Longacre Bungalow
Maypole Lane
Yapton
West Sussex
BN18 0DR

Your ref Y/15/11

Change of use from (C3) dwelling to (D1) day nursery Longacre Bungalow, Maypole Lane, Yapton.

Existing First Floor Plan

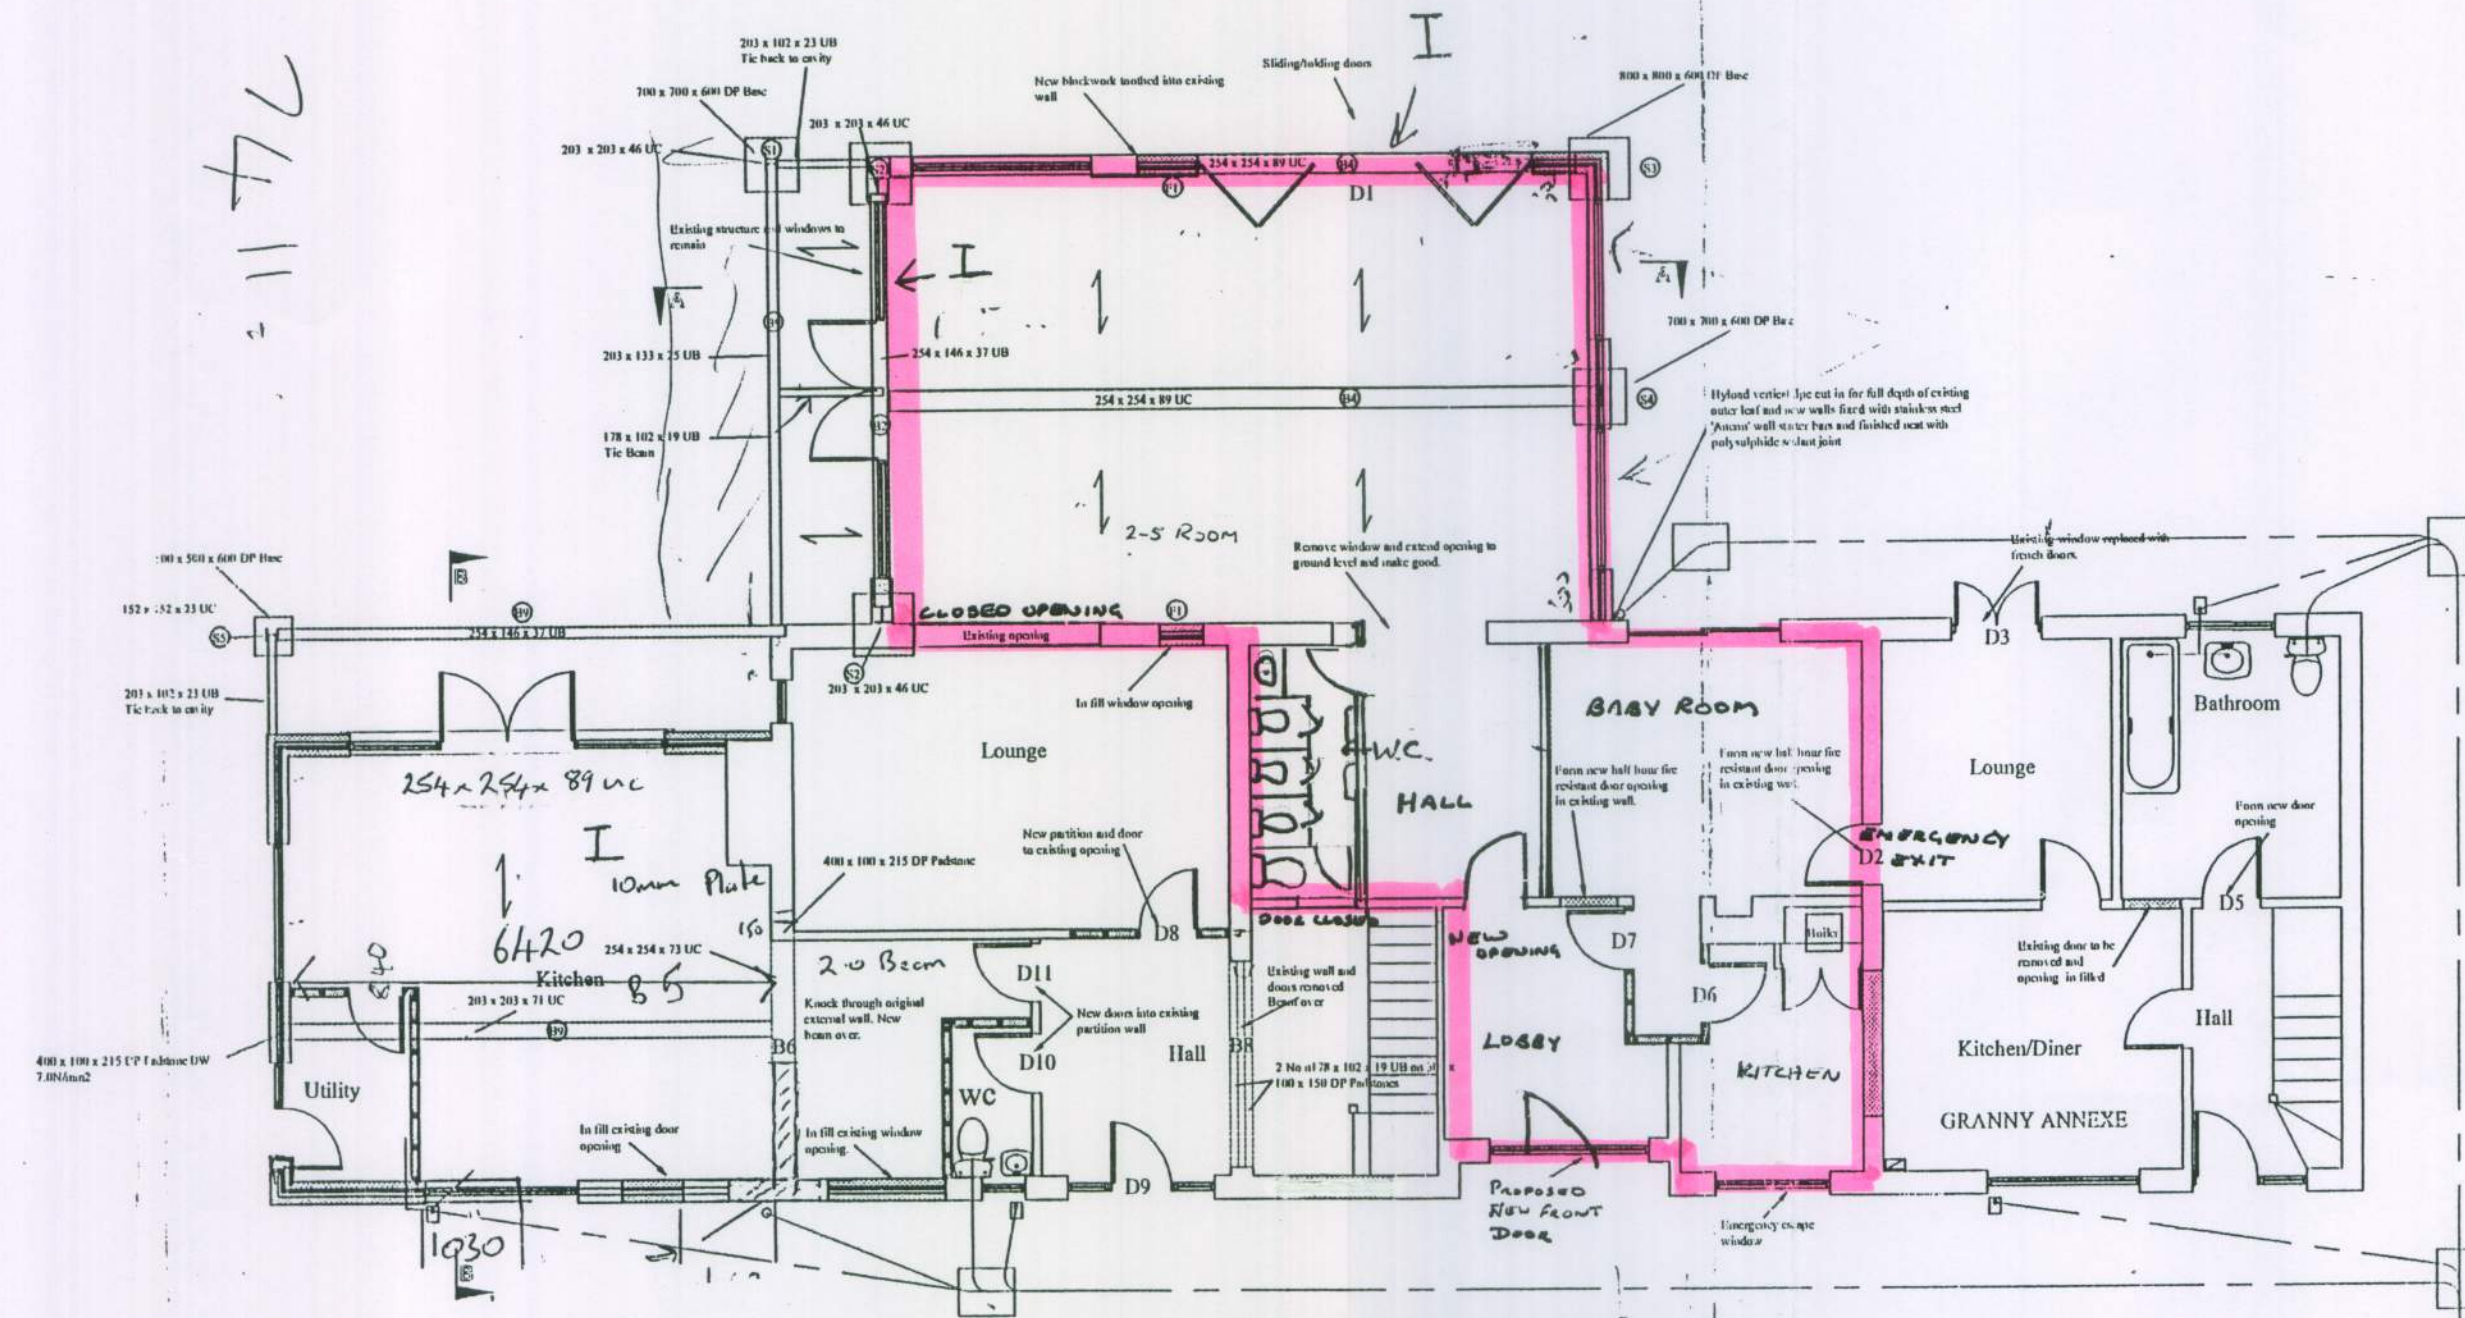
I have also amended the existing first floor plan to show 3 rooflights shown on the existing West elevation. As requested in paragraph 5.

I have also amended the existing first floor plan to show the window that is shown on the proposed West elevation. The rooflight is shown but as it is a chalet roof it is indicated on the middle line of the plan. As requested in paragraph 6

Proposed First Floor Plan

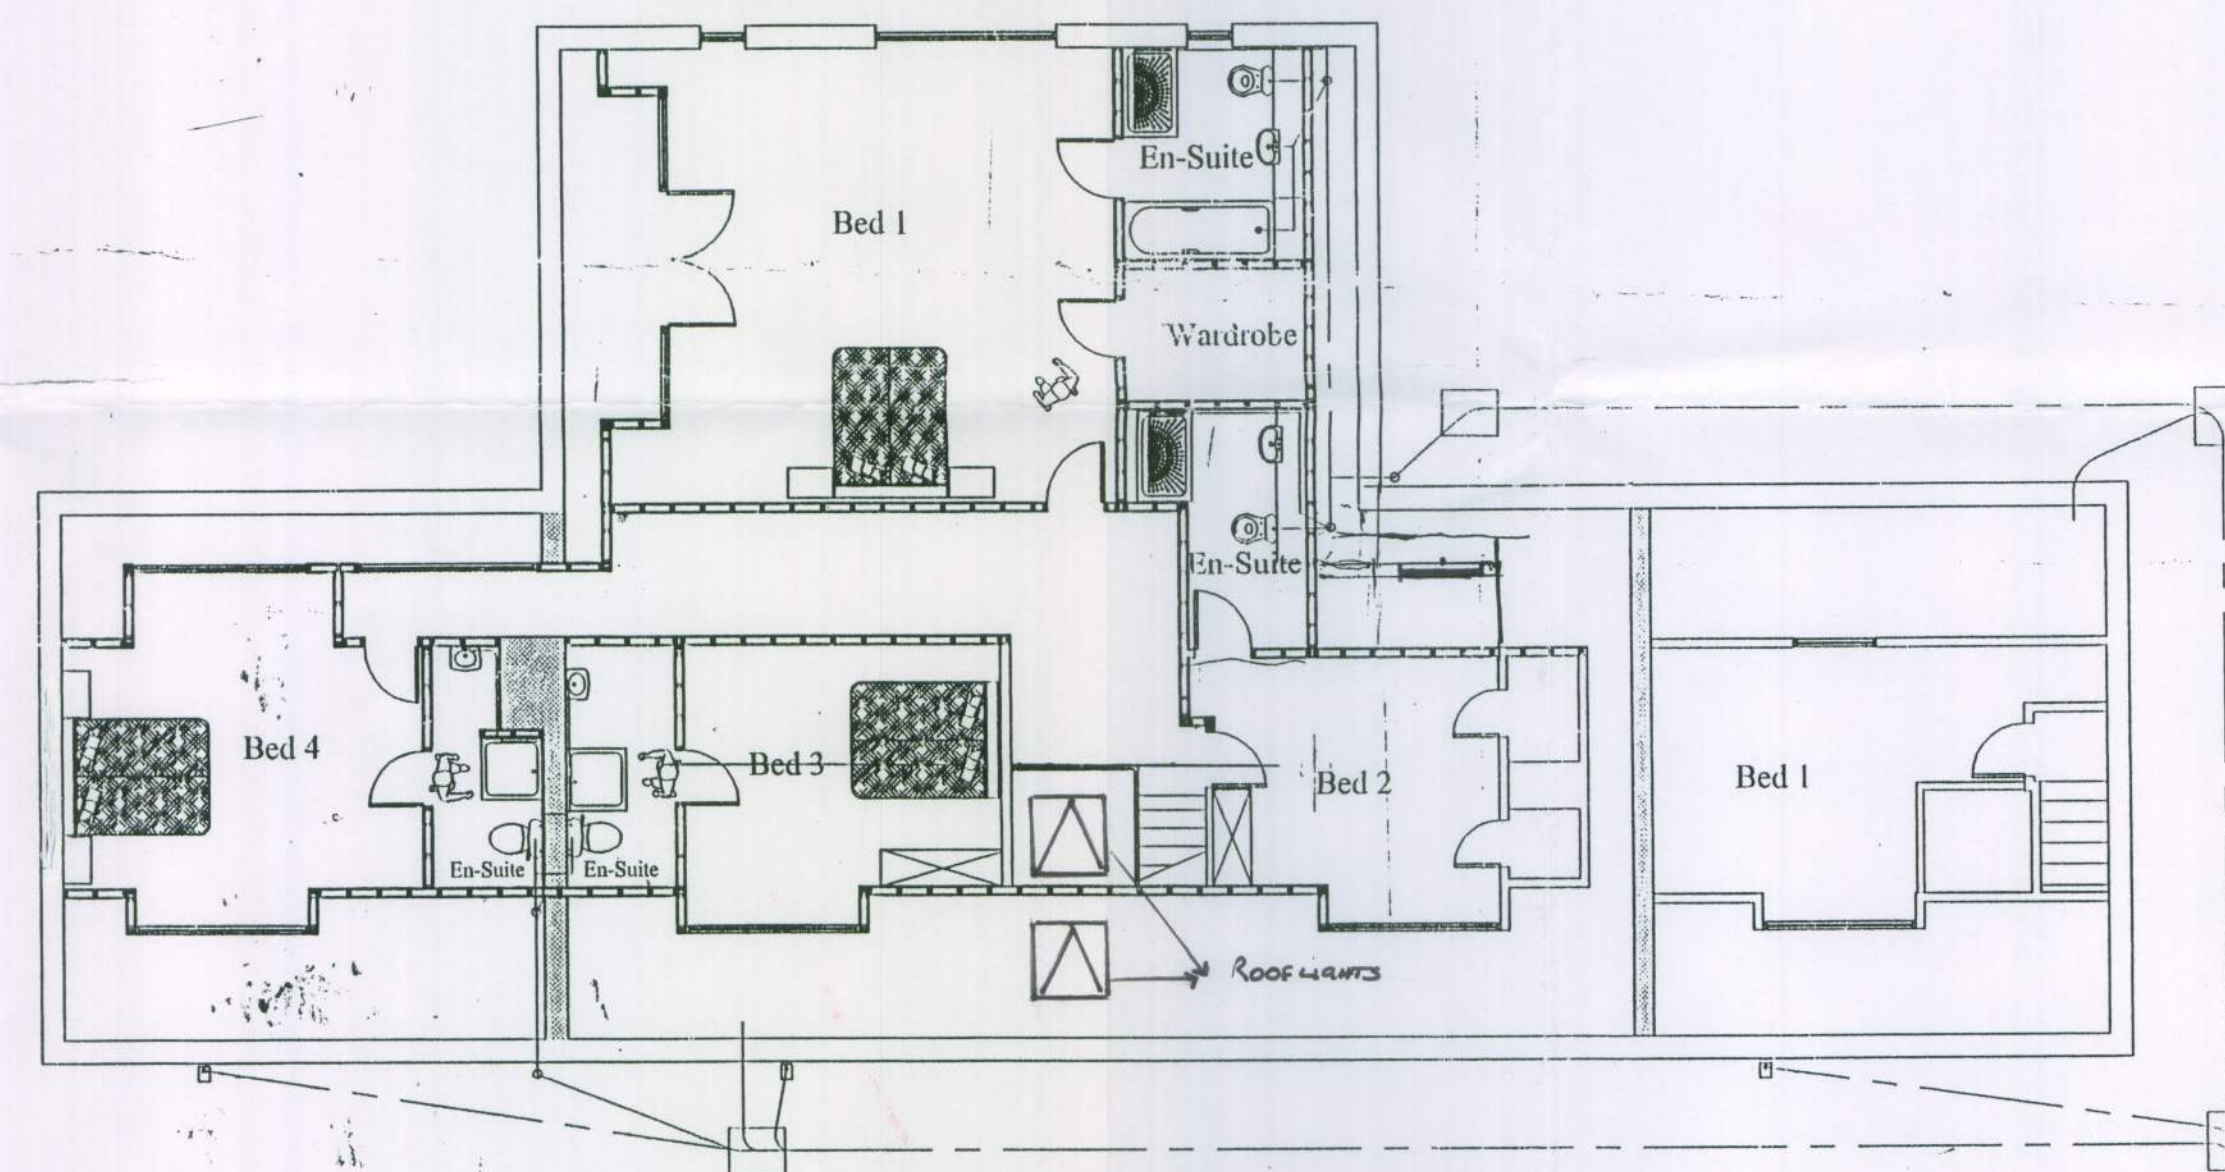
The 2 rooflights that have been omitted and that I have previously referred to were on the North elevation first floor. I have amended the drawings accordingly. I have also amended the proposed first floor plan to show the 2 rooflights on the East elevation. As requested in paragraph 4
